Consultation Response from KC Waste Strategy (Refuse & Cleansing)		
PA no. & address: 2020/94285 22-26, Wellington Road, Dewsbury, WF13 1HL		
Proposal: Alterations to office building to form 20 flats and associated office space and laundry (Listed Building within a Conservation Area) – AMENDED GROUND FLOOR AND LAYOUT PLANS		
Date Responded: 12/07/2021	Responding Officer: Carol Oakden	Responding Ref: WPN-20-065R1

The following comments relate to revised drawings 556.22 (--) 007 Layout plan, and 556.22 (--) 002RevF Ground floor plan.

Dwg. No. 556.22 (--) 002

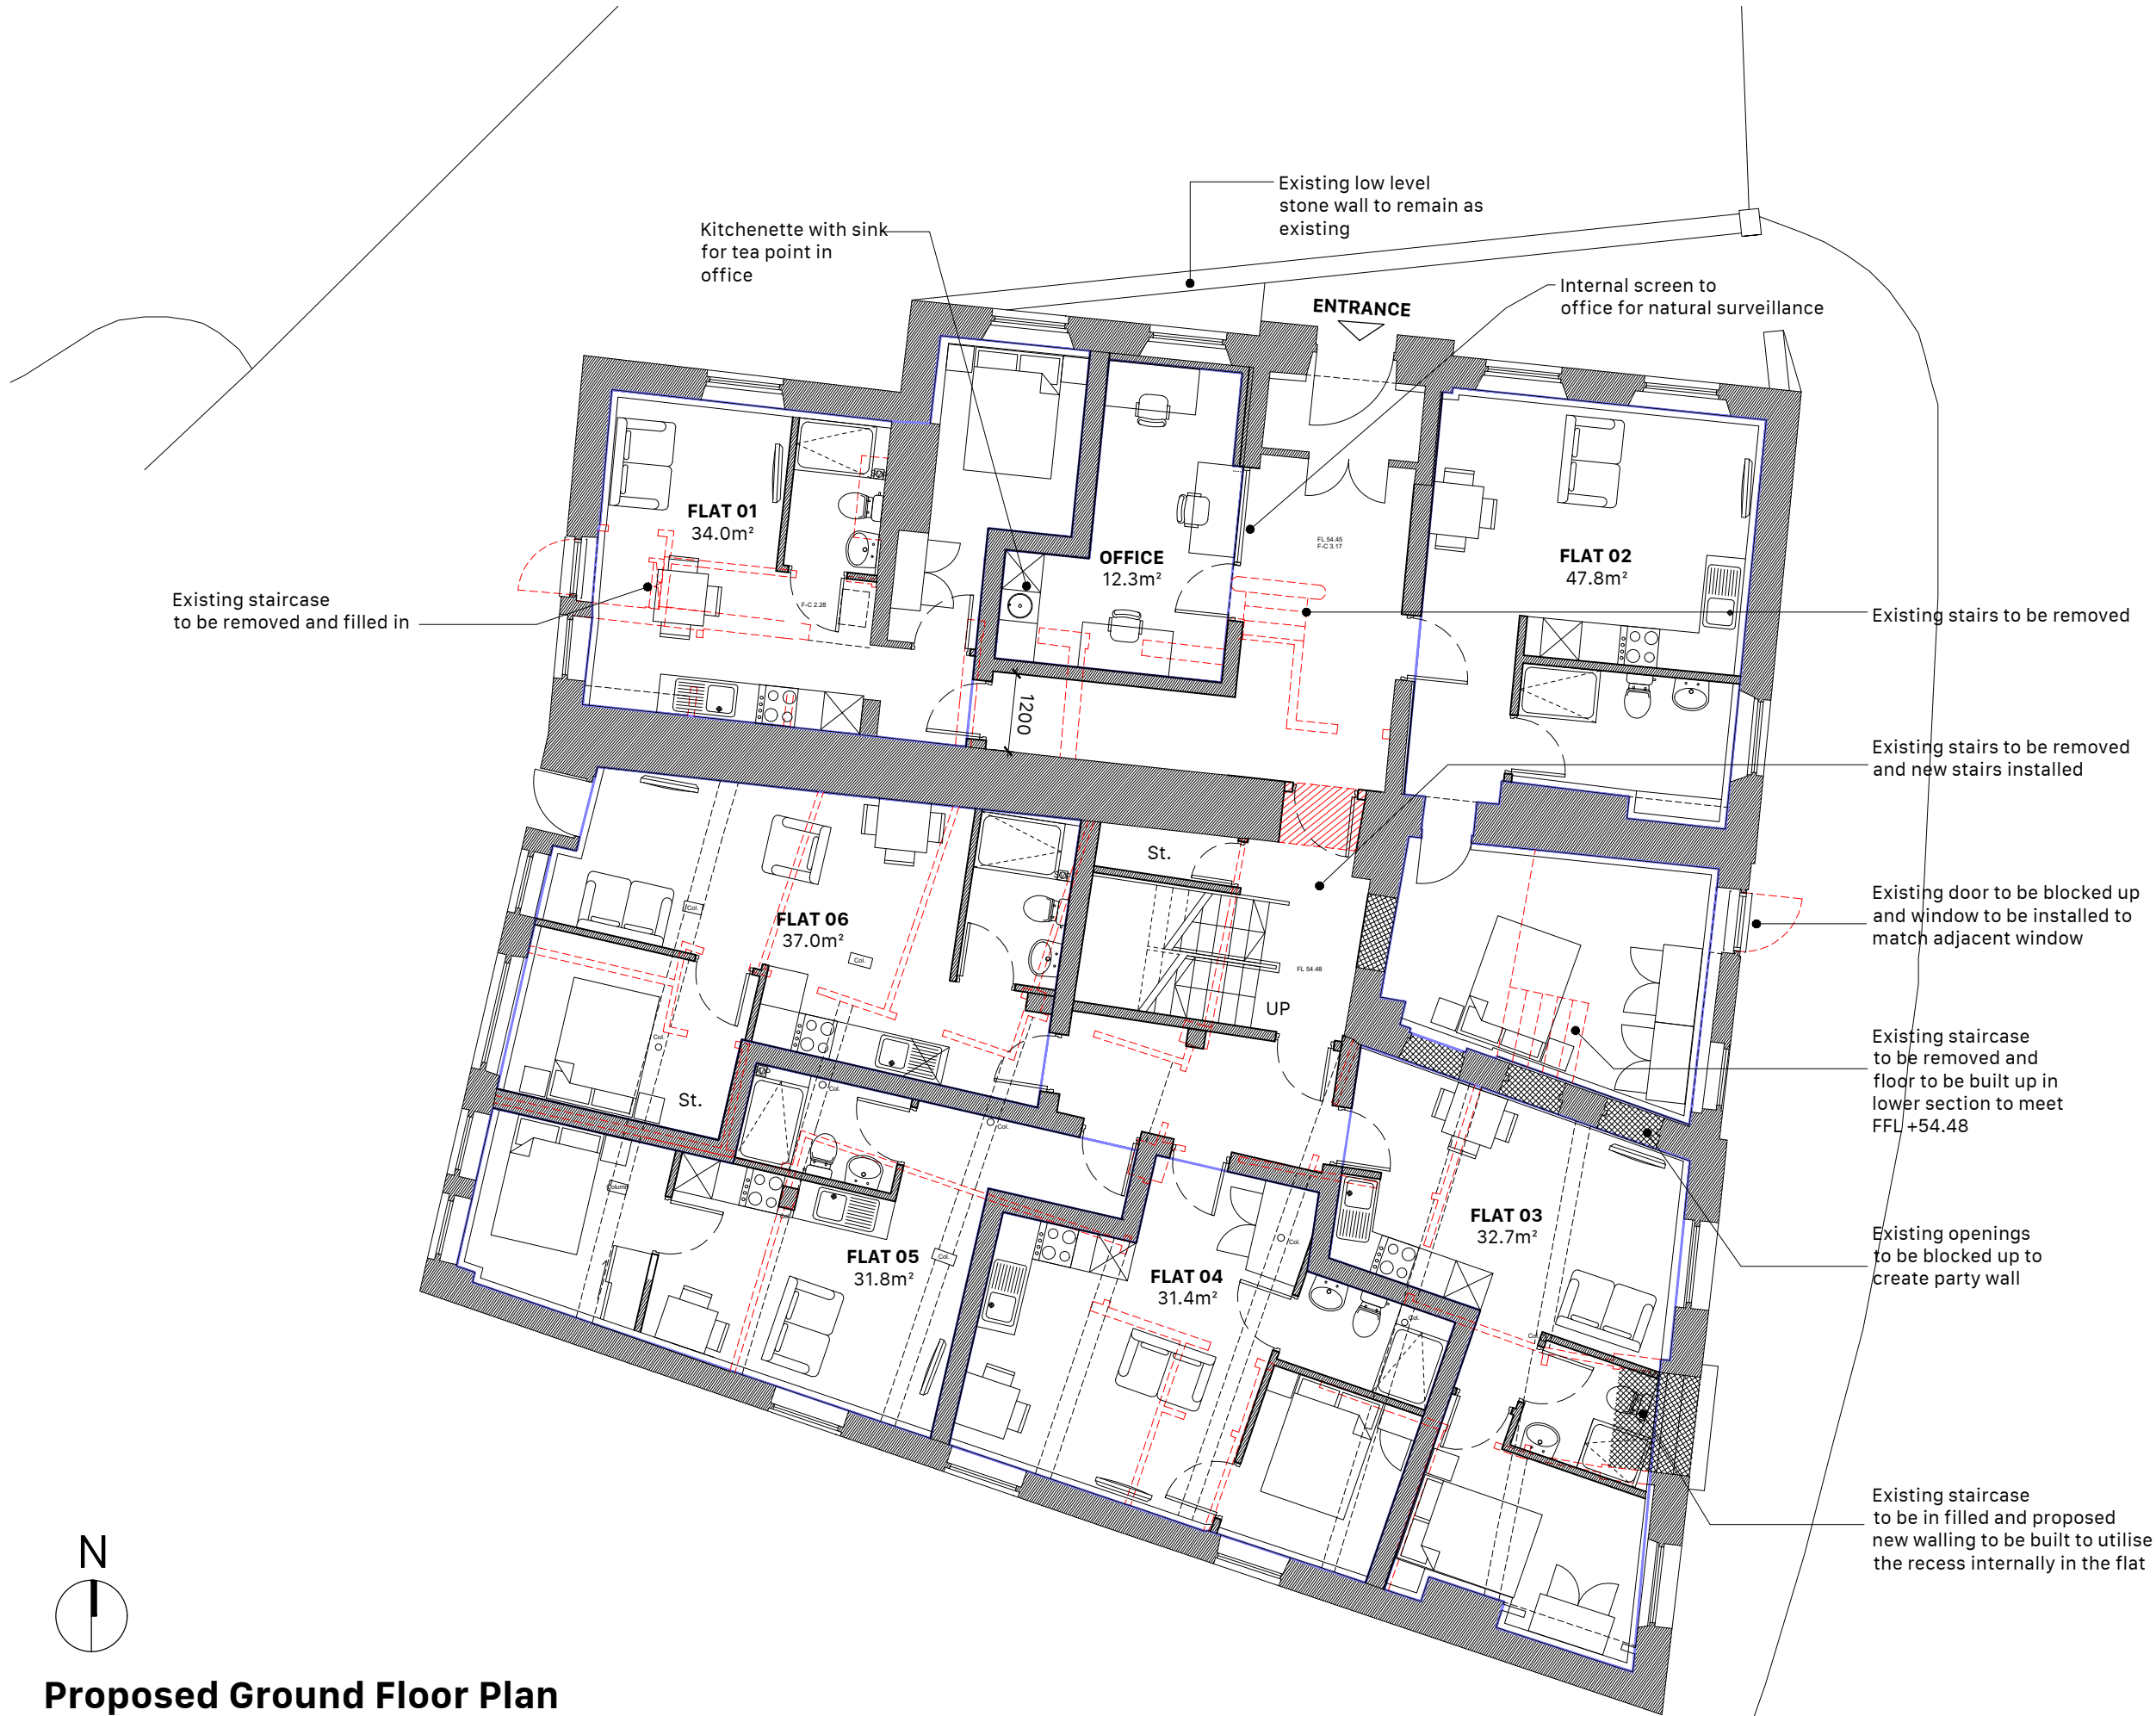
The revised plans now show 3 x 1100ltr bins to be stored to the front of the building within a low-level stone-built enclosure with double doors for each bin. This still falls short of the Authority's requirements in that:

1. The proposed storage doesn't accommodate the required number of bins for the size of the development. As previously stated, 6 x 1100ltr bins are required in line with the Authority's fortnightly collection schedule and allowing for recycling facilities to be included. Failure to provide sufficient space will most likely result in extra collections being required. Extra collections will attract a charge from the Authority, and we cannot guarantee being able to provide such a service. Overspill waste resulting from inadequate storage will be the responsibility of the landlord to deal with. More regular private waste collections could be purchased by the landlord/building management company to overcome this, but the details of such arrangements would have to be specified via a pre-occupation Planning condition to ensure that adequate and traceable arrangements are in place in accordance with the statutory responsibilities of the Waste Collection Authority.

2. The design of the store with the inclusion of doors (presumably lockable) does provide secure facilities for bins – helping to prevent them being moved around/stolen, targeted for arson or mis-used. However, with no roof, being within 6m of the residential building and being close to the principal egress route for residents, the fire risk presented by the bins is not adequately mitigated. **Upon inspection, Building Control and/or the Fire Authority may request changes to the construction of the bin store to mitigate the risk and may even require it to be relocated.** It would therefore be prudent to address this as soon as possible.
